**CHANGE OF USE OF EX-BELL PUBLIC HOUSE TO A SHOP (CLASS E) INCLUDING PART
DEMOLITION, SINGLE STOREY REAR EXTENSION & EXTERNAL WORKS**

**THE BELL INN, 33 CHURCH STREET, PINCHBECK, SPALDING, LINCOLNSHIRE, PE11
3UB**

Application No H14-0523-26

Comments on consultation responses

PROPOSED SITE LAYOUT
scale 1:200

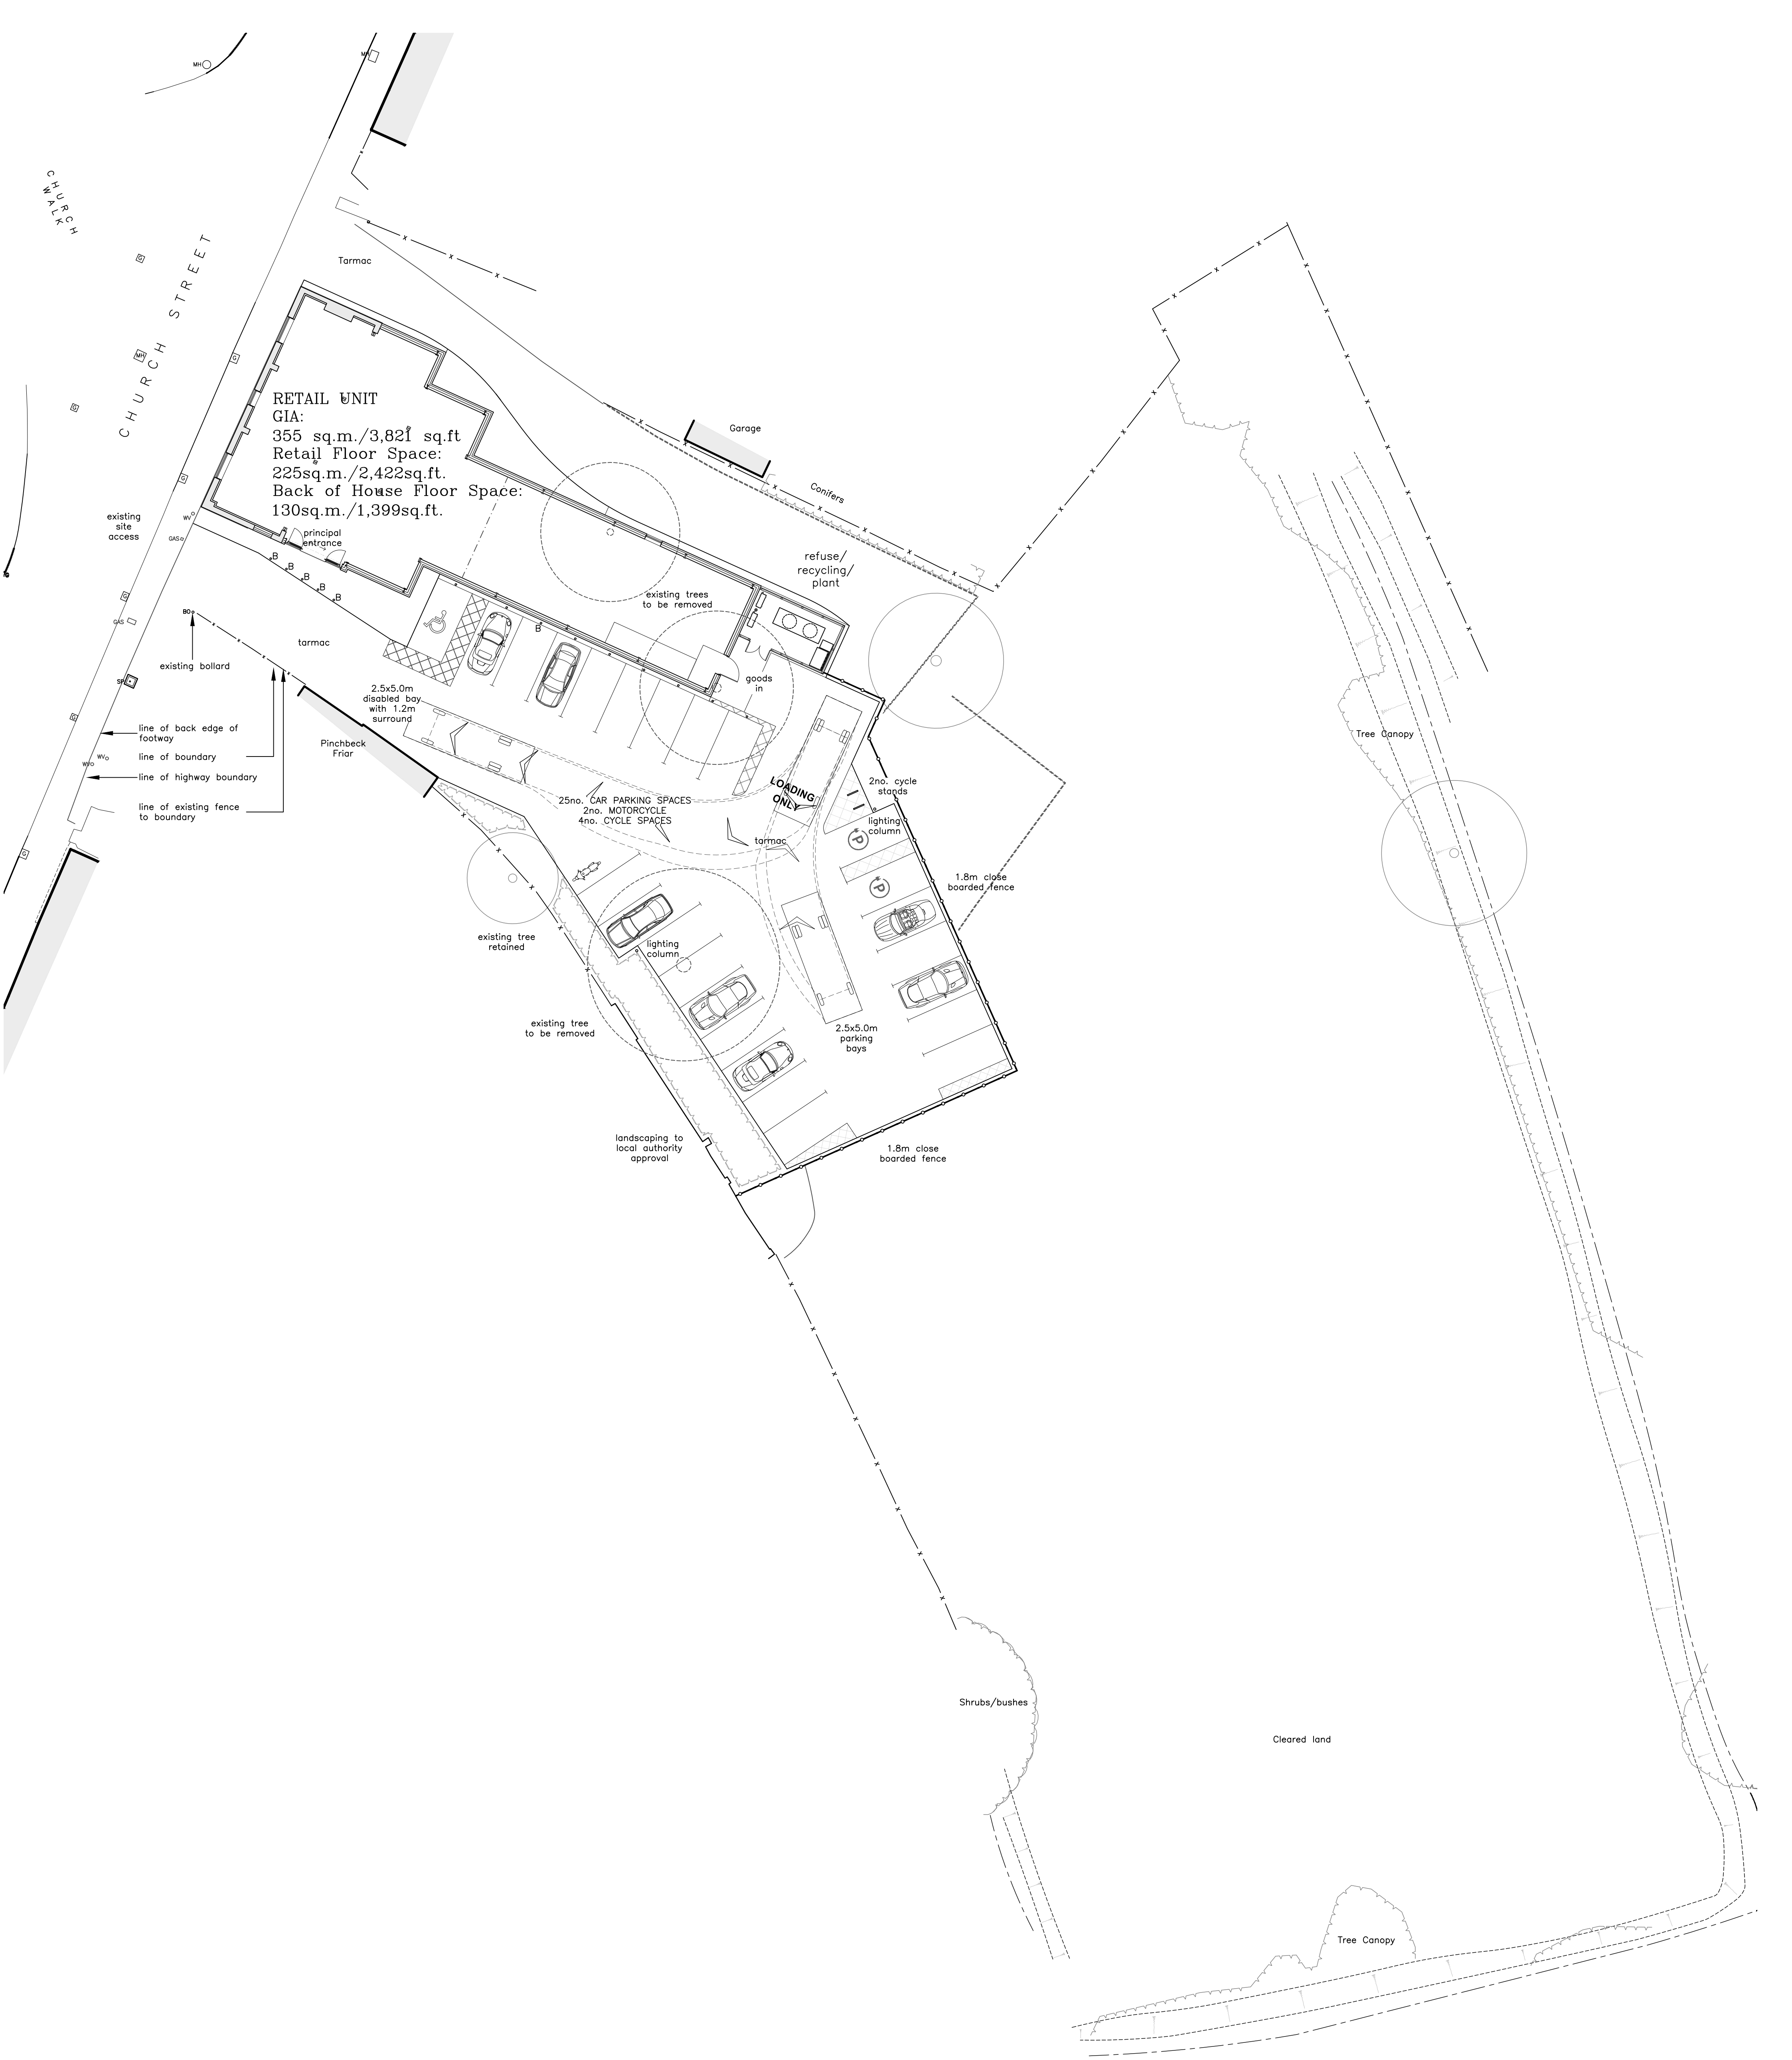
1 ☐ The preliminary roost assessment identified that tree T443 contains two potential roost features; however, no evidence of roosting bats was recorded at the time of survey. The proposed development includes the removal of this tree. Given the recorded bat activity within the area, we recommend that T443 is retained and incorporated as a feature within the car park. This would ensure the retention of two potential bat roosting features on site. BNG Comments and Notes to applicant ☐ Overall, the biodiversity assessment and metric calculations appear rigorous, and we can have confidence in their conclusions. In this case the metric indicates that 10% mandatory net gain cannot be achieved on-site, and therefore the proposals require 1.14 area-habitat units on-site. These will need to be secured pre-commencement and can be achieved via 2 routes:

Retention of T443 has been carefully considered. However, its retention would result in the loss of four parking spaces and the principal turning area, thereby potentially creating the highway and parking concerns identified by the Parish Council and previously raised by the Highway Authority. The layout cannot therefore reasonably accommodate the tree without prejudicing the safe and effective operation of the site. Appropriate ecological compensation will be incorporated into the biodiversity gain arrangements. This should also be weighed against the substantial benefit of securing the viable reuse and long-term retention of the former public house, which is identified as a non-designated heritage asset.
